**Transport  
for NSW**

**North Shore Private Hospital (SSD 7543)  
Notice of Exhibition**

## TAB A – EIS Comments

Figure 2.8: State Transit Region Guide

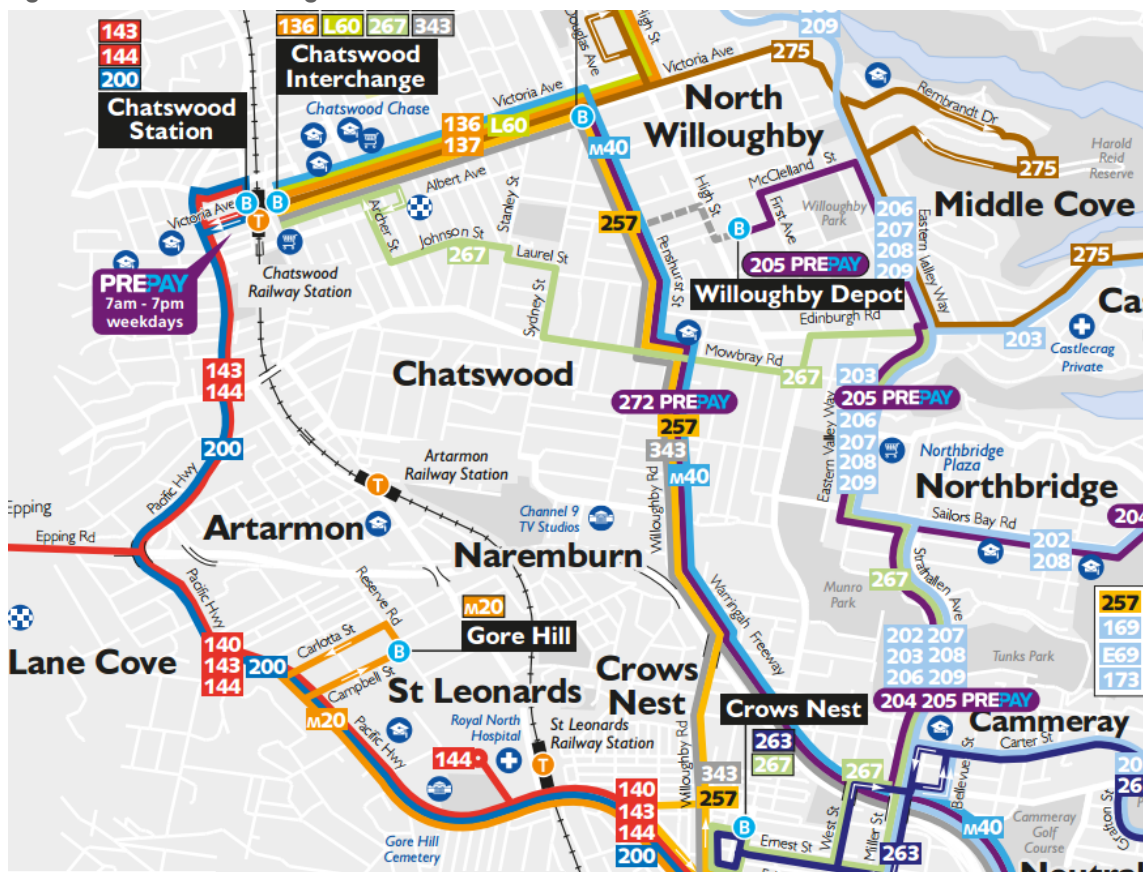
It should be noted that Section 2.6 'Public Transport' of the TIA has the following inaccuracies and omissions:

- Figure 2.8 'State Transit Region Guide' is outdated, the most updated network guide can be found at <https://transportnsw.info/document/1697/region-guide-sydney-north-shore-west.pdf>.
- Hillsbus operate routes via 602X, 612X, 622, and 653 via the Pacific Highway; however the site is outside the 400m catchment zone of bus stops on these routes.
- No reference is made the shuttle bus services provided by Willoughby City Council. This service operates directly outside the subject site's frontage. Details of this route can be found at <http://www.willoughby.nsw.gov.au/Community/Traffic---Transport/Artarmon-Loop/>.

TfNSW advises that the TIA should be updated to reflect the provision and accessibility of bus services surrounding the site.
